Application No: AW/3/21/HH
Site Address: 4 Shorecroft Aldwick PO21 4AS
Description of works: Single storey rear extension and loft conversion with enlarged rear dormer window and two modest front facing dormer windows. Alterations to fenestration, Canopy to side elevation, Planter and replacement handrail to roof terrace.

Thank you for your internet representation made on 2nd February 2021 which has been recorded as an objection with the comments as follows:

NORTH ELEVATION

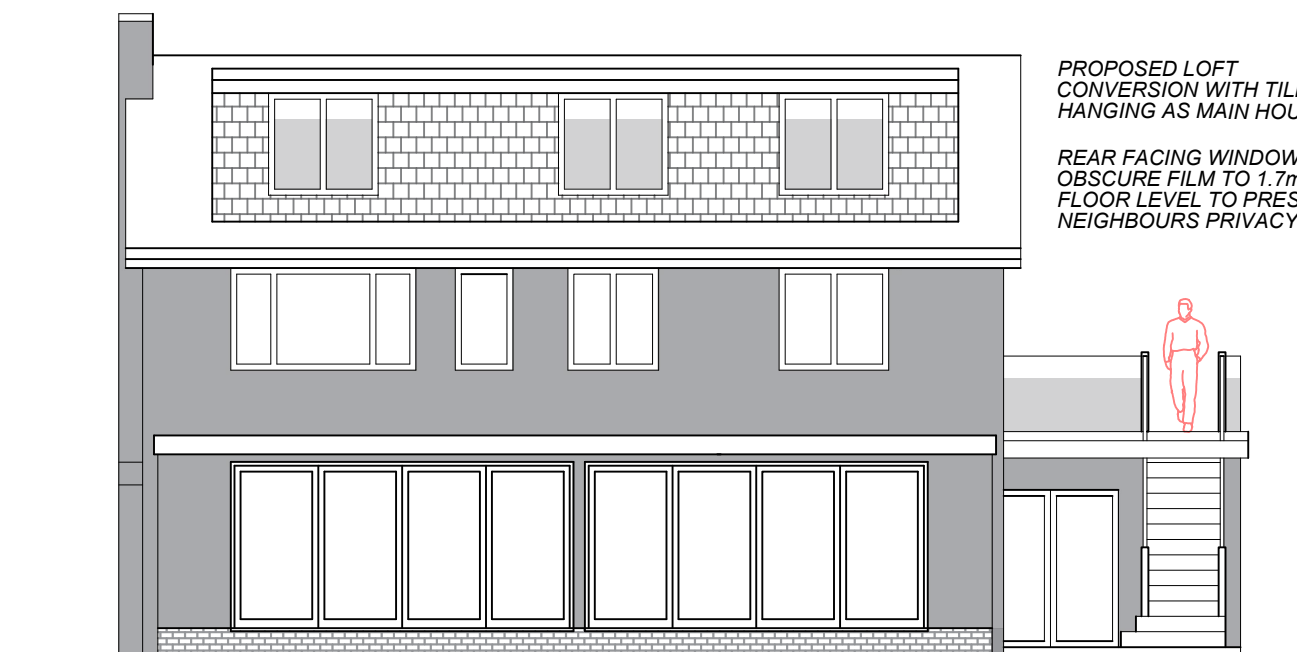
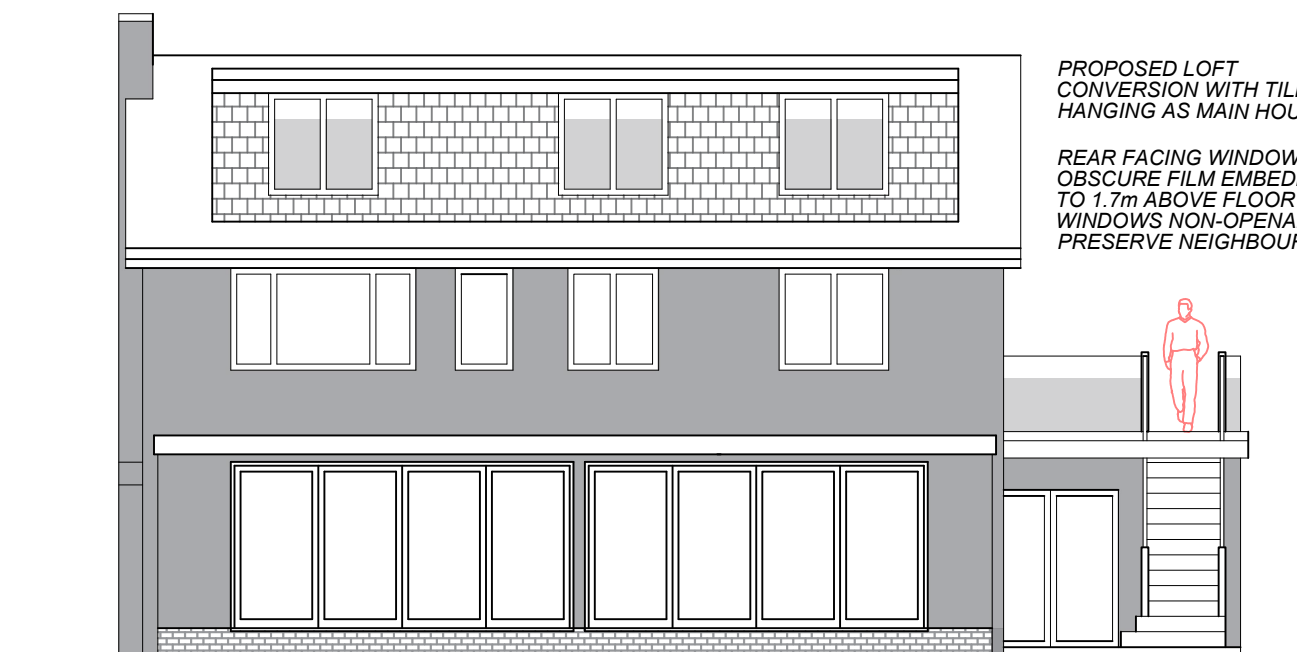
The actual plan shows obscure FILM, however obscure fixed glass to the whole windows rather than obscure film to a height of 1.7m from the floor, is the only permanent solution. Windows should also have restricted opening.

Drawing No. Date:
C.1062H - 04 22-12-20

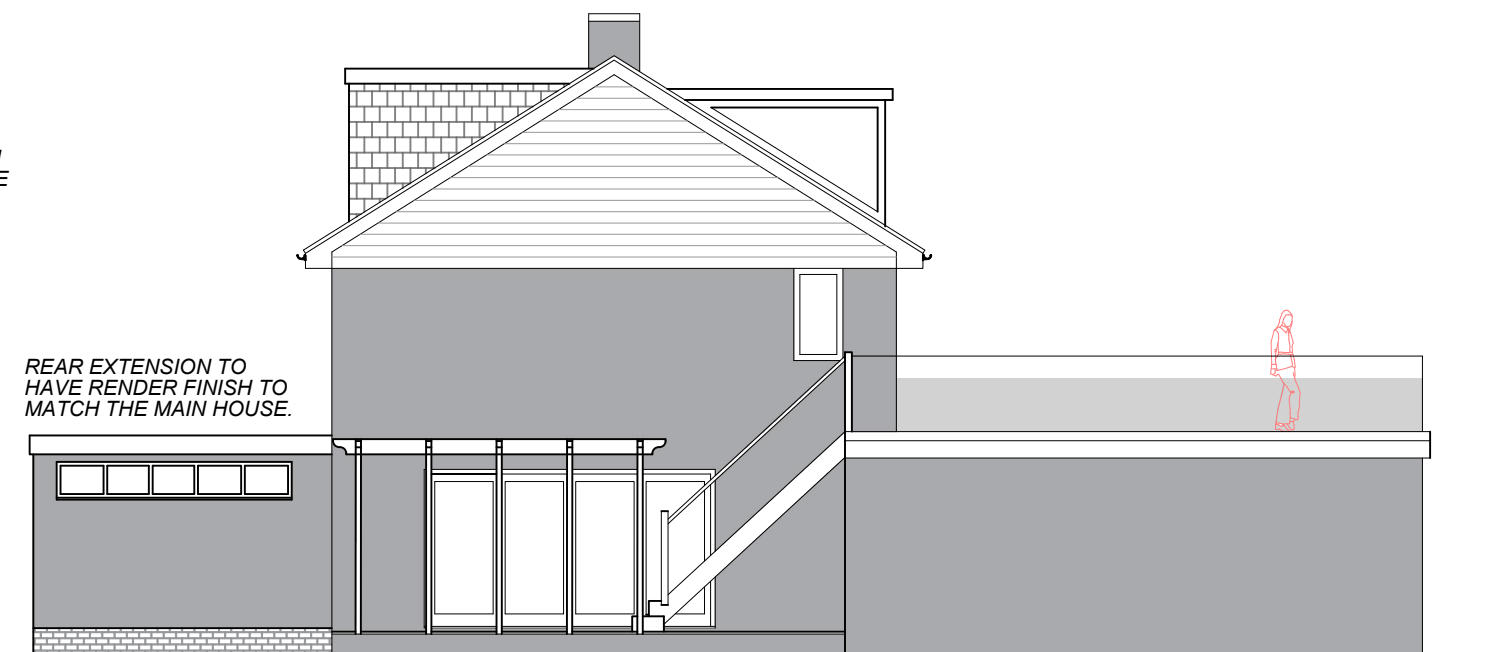
This application fails to meet any of these statements. The overall style and design of the rear box extension contributes nothing to enhance the design and visual appeal of the surrounding area, where open space is a prominent feature. This proposed extension will be totally overbearing due to its bulk and box style appearance and will completely overwhelm the three bungalows to the rear. Furthermore its bulk will be out

of keeping and character with all other surrounding properties as this would be the only property with three floors of accommodation on the Aldwick Place Estate. This proposal would dominate the locality as a result of its scale, bulk and unbalanced roof appearance and will be harmful to the visual amenity of the area.

This proposal can not be considered proportionate when its scale, bulk and unbalanced roof appearance will create the only property with three floors of accommodation in its locality and overwhelms its three closest bungalows to the rear.

The visual impact from the bungalows to the rear is considerably harmful in outlook and visual amenity due to the increased height and viewing angle. With the only property with three floors of accommodation, it would dominate the immediate area due to its scale and bulk. Not only would it be clearly visible from Aldwick Place and Wallfield, the west roof elevation would have unobstructed views from the furthest point in Shorecroft and Hornbeam Close. Outside of the Aldwick Place Estate, this proposal would also be clearly visible from properties in Aldwick Avenue and Woodstock Gardens to the East. This proposal could not be more detrimental to the visual appeal of its surrounding area.
